**RE: Townhome for Jason Buchanan
1106 Griegos NW
Request for Certificate of Occupancy – Permanent
Hydrology Final Inspection - Disapproved
Grading and Drainage Plan Stamp Date: 12/20/18
Certification Dated: 10/24/19
Hydrology File: F14D058A**

Based on the submittal received on 10/29/19, this certification cannot be approved in support of Permanent Certificate of Occupancy by Hydrology until the following are corrected:

DRAWING:	DRAWN BY:	DATE:	SHEET #
201843-GD.DWG	SH-B	12-06-2018	CIVIL 102

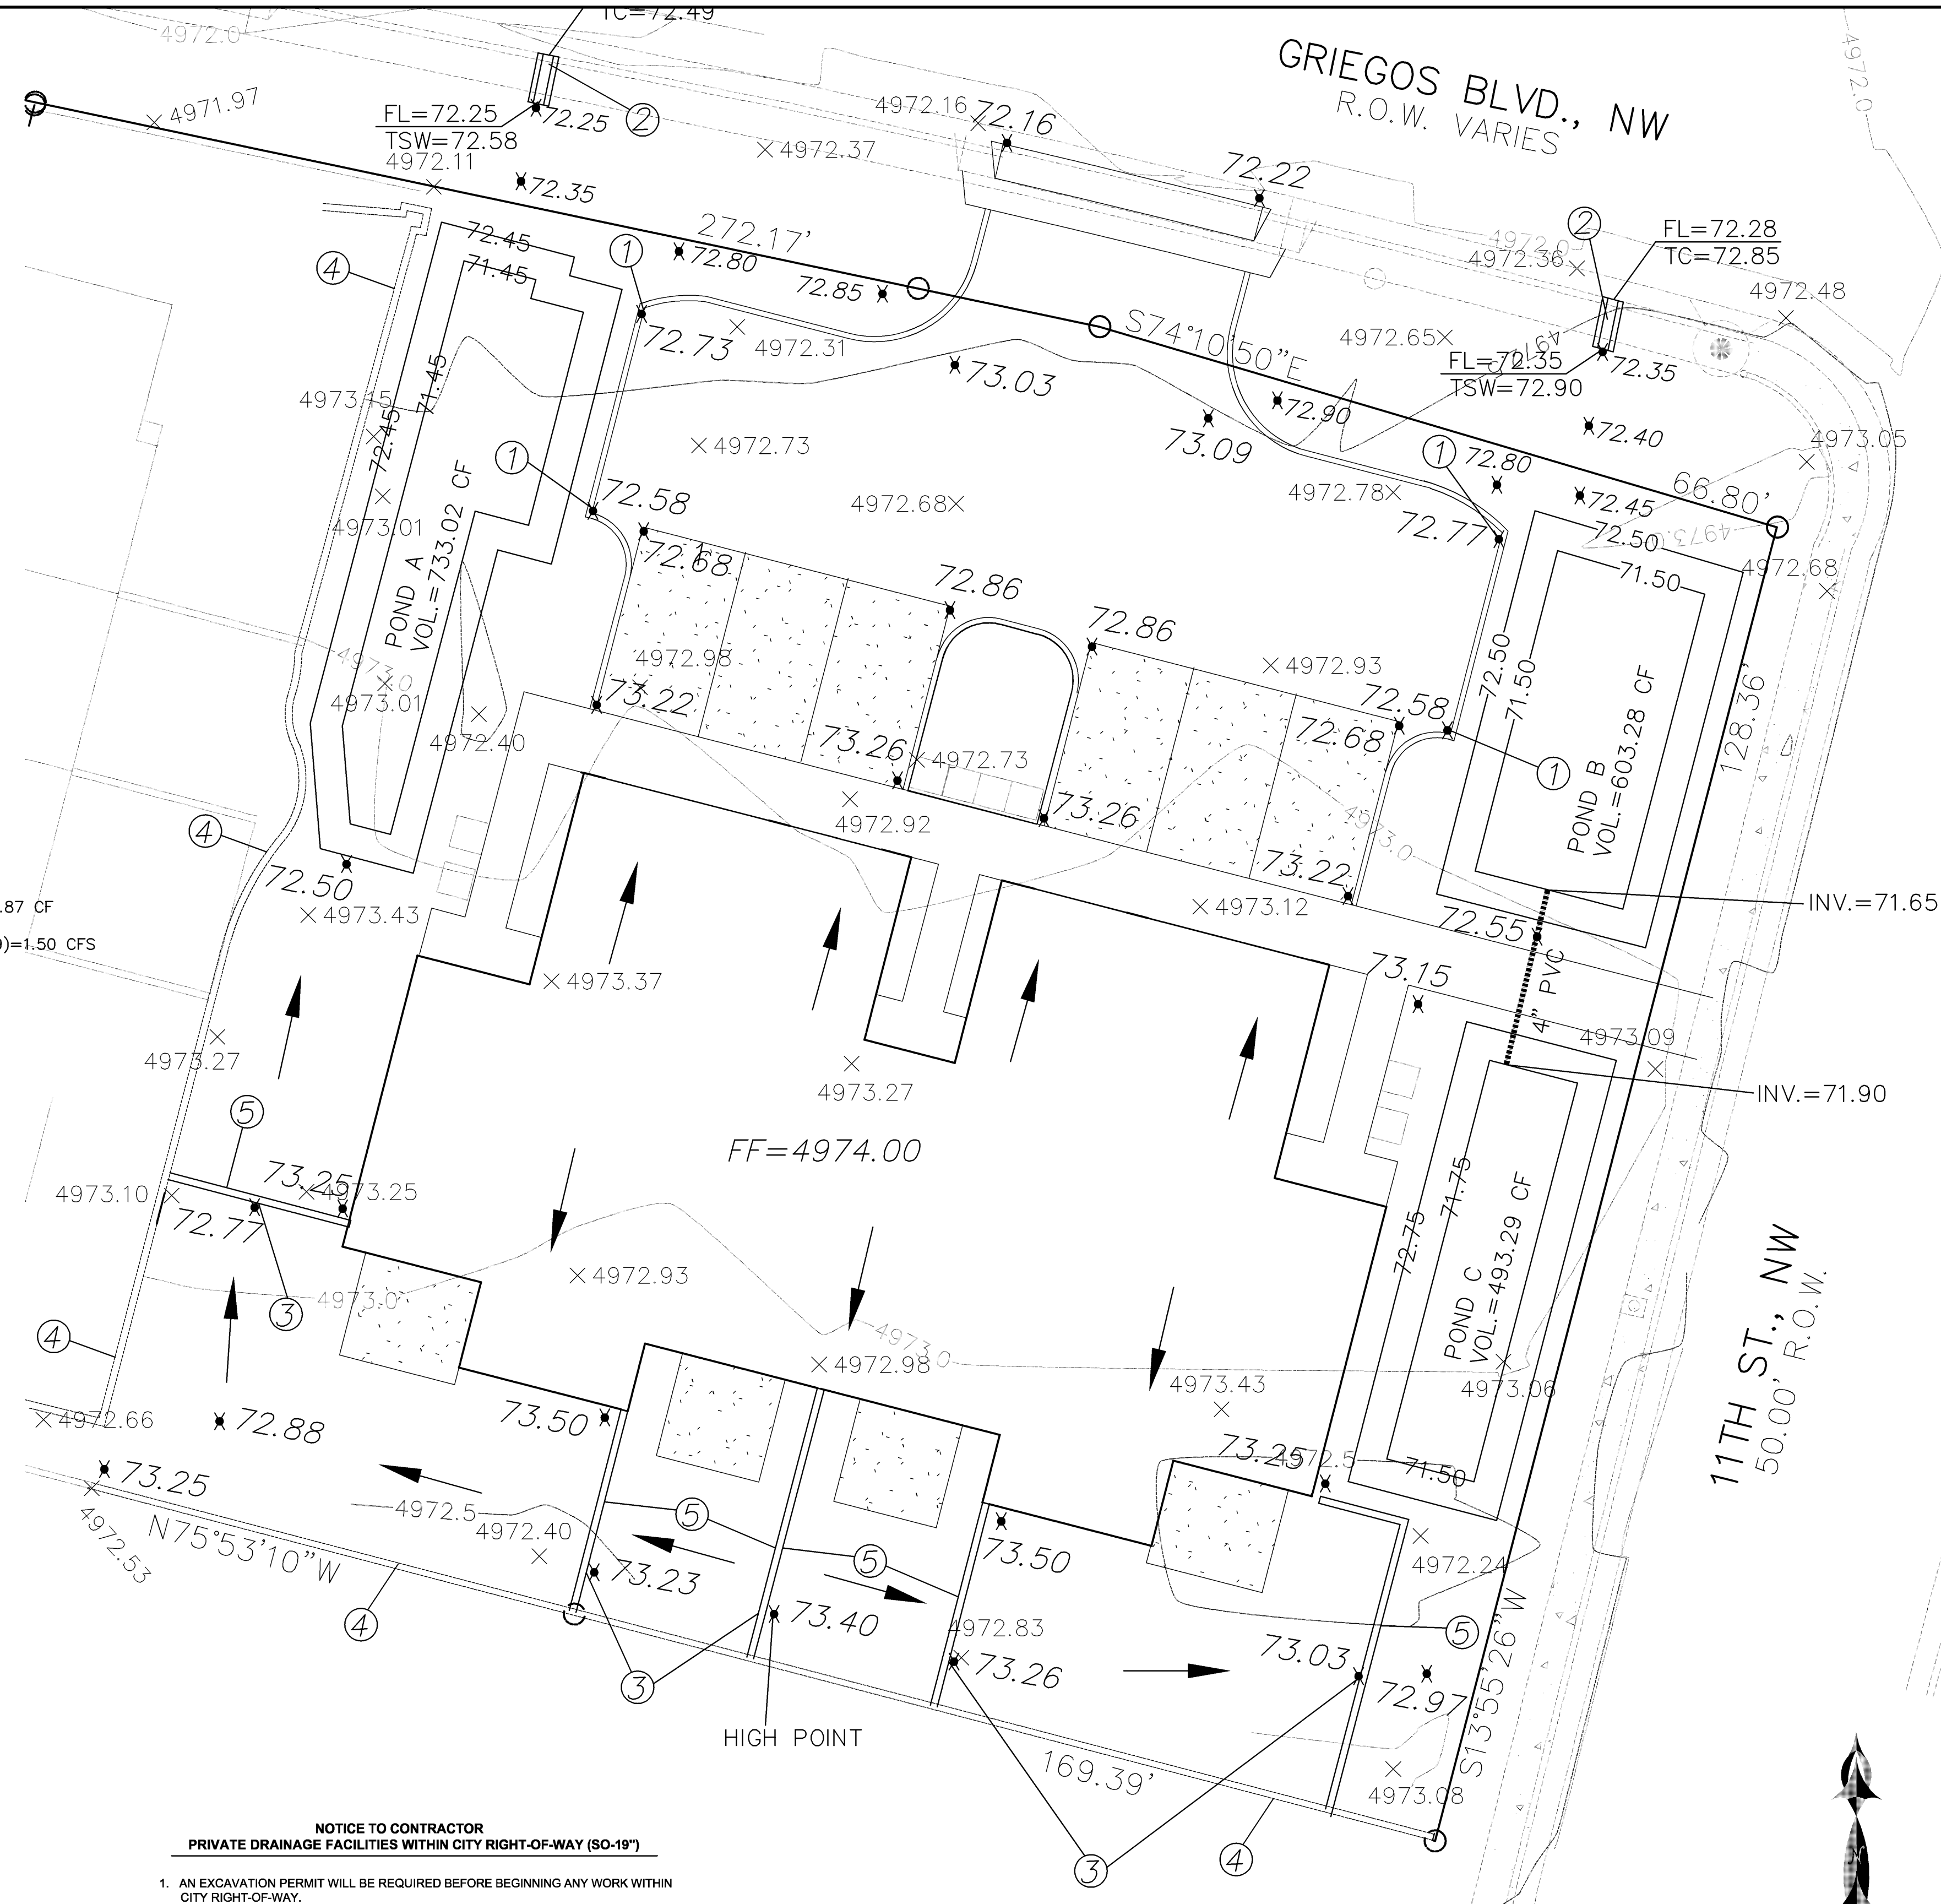
1. A Bernalillo County Recorded [Drainage Covenant \(No Public Easement\)](#) is required for the stormwater control pond. The original notarized form, exhibit A (legible on 8.5x11 paper), and recording fee (\$25, payable to Bernalillo County) must be turned into DRC (4th, Plaza del Sol) for routing. Please contact Charlotte LaBadie (clabadie@cabq.gov, 924-3996) or Madeline Carruthers (mtafoya@cabq.gov, 924-3997) regarding the routing and recording process for covenants. The routing and recording process for covenants can take a month or longer; Hydrology recommends beginning this process as soon as possible as to not delay approval for certificate of occupancy.
